# **A47/A11 Thickthorn Junction**

**Scheme Number TR010037**

## **8.11 Statement of Common Ground with Big Sky Developments Ltd**

March 2022

Drawing Number: HE551492-GTY-LLO-000-DR-BL-30006	Rev: P04
--	----------

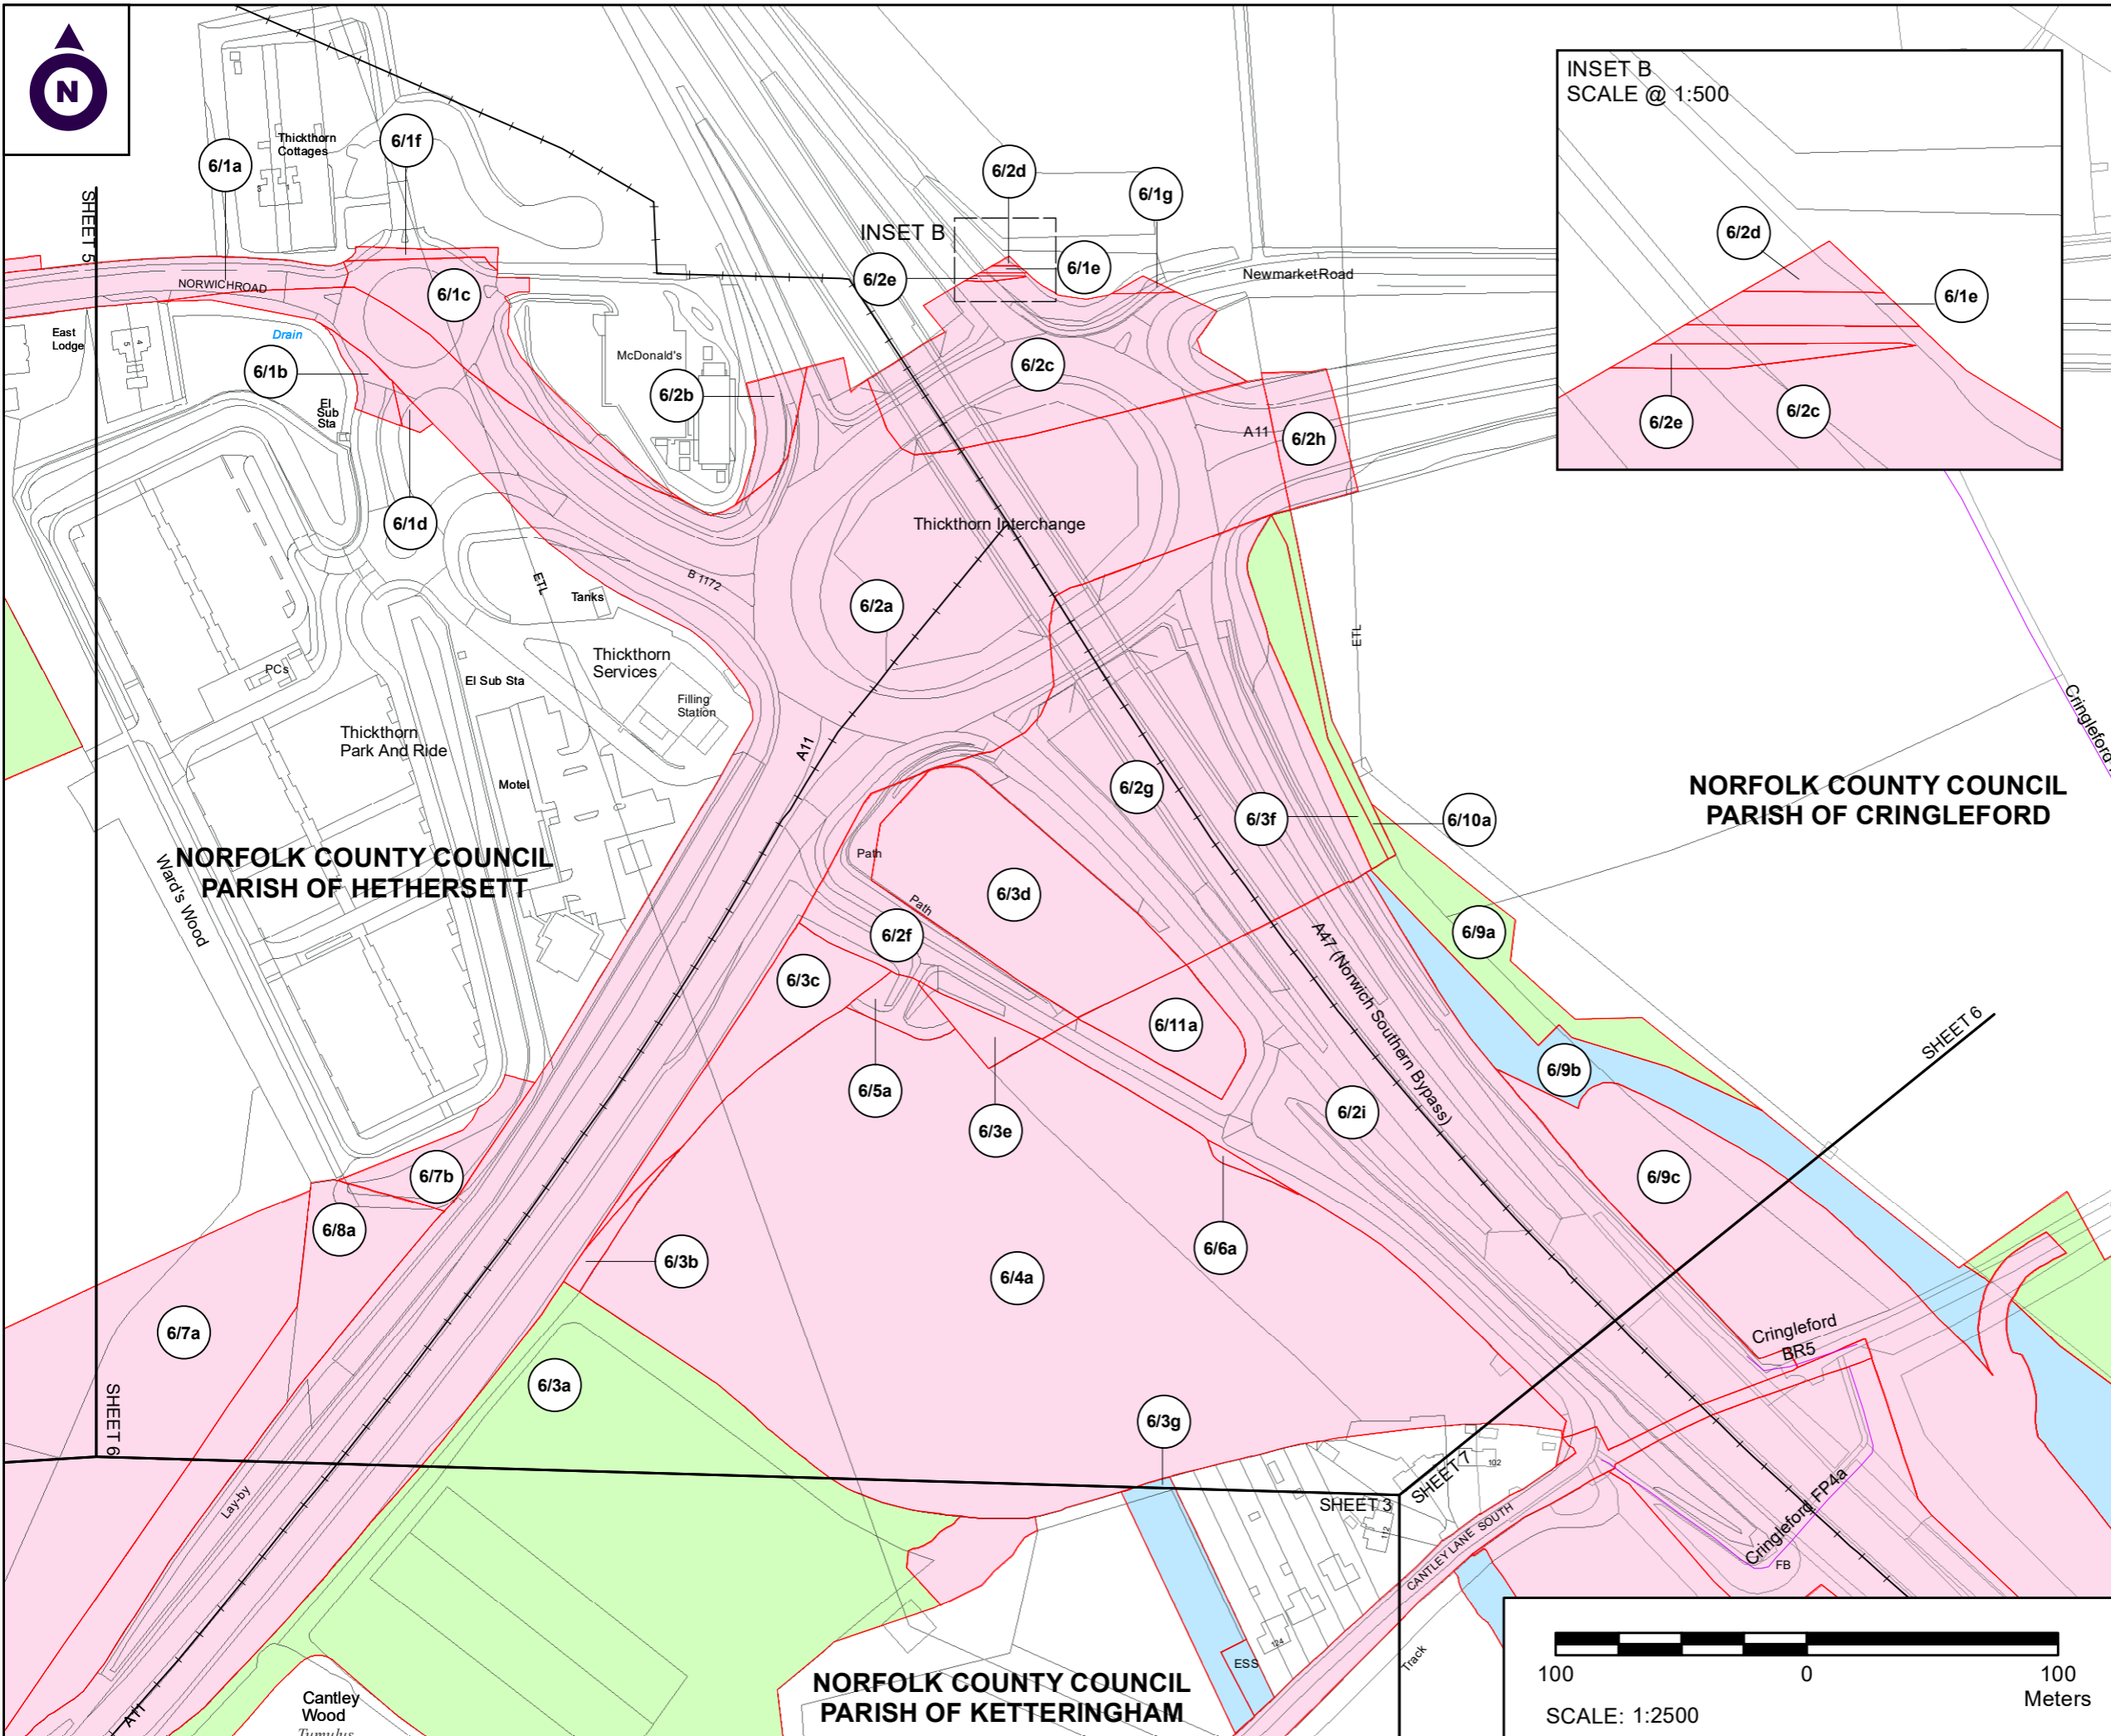
5	Site Compound		<p>The triangular compound reference 7/7c will occupy land designed for three houses and will affect the ones immediately north, as services and accesses cannot be completed, and the phase of the development cannot be completed. Our understanding is that timescales will coincide badly:</p> <ul style="list-style-type: none"> <li>i. A47 Thickthorn Scheme timing Works from Early 2023 to December 2024, if there are no delays.</li> <li>ii. St Giles Park development timing. Phases 14 and 16 works from early 2023 - to be completed by Autumn 2024, with the development completed and contractors off site by the end of 2024. There was mention that the site would be used for welfare facilities rather than for the construction compound and material storage area referred to in the general arrangement plan. The contractor or the Applicant may indicate they require storage facilities on this site, but there is a significant area on land which is expected to be under the Applicant's control on the southern side of A47, shown on Plan 6 the PCF Environmental Masterplan</li> </ul> <p>If the site (plot 7/7/c) is to be used for welfare facilities with portaloos and an office or welfare base, the site does not need to be 1.7 acres or so. This use could be accommodated along the hard surfacing of Cantley Lane, a closed off road used only for public access. Alternatively, the site could be restricted to the south of the overhead UKPN overhead pylon line which is reserved for public open space after completion. it would not prevent</p>	<p>Plot 7/7c is required for a site compound, welfare facility, parking and some storage. The Applicant will be able to confirm the exact area required once the detailed design has been prepared and will try to minimise the temporary land take in this area. However, the extent of land shown on the land plans is the land that is required to ensure the Scheme can be delivered at this stage of the design process. The Applicant is under a legal obligation to provide welfare facilities and this is the only area where these can be provided, whilst complying with the Construction (Design and Management) Regulations 2015.</p> <p>The Applicant will continue to explore options relating to the location of the Site Compound with Big Sky Developments and minimising the footprint of the compound facilities.</p>	Agreed	11/03/22

<p>construction, and interference will be time limited. If the Applicant can persuade their contractors, or they can be pressurised to omit this area of conflict or time limit their occupation, we request that a deadline is set for removal of the compound from the land so the landowners can provide guarantees to buyers.</p> <p>If the site is to be used for a construction compound the impact is greater. We remain concerned about the proximity of works and the impact of the compound on new adjacent residential properties, but this is much more severe if houses cannot be built at all. We are concerned about the planned exit from site by Autumn 2024 as the Thickthorn works are also designed to complete then. The owners will be prevented from selling in advance and from building through the period proposed through 2023 and 2024. This produces problems of breach of contract, penalties, and preliminaries.</p>
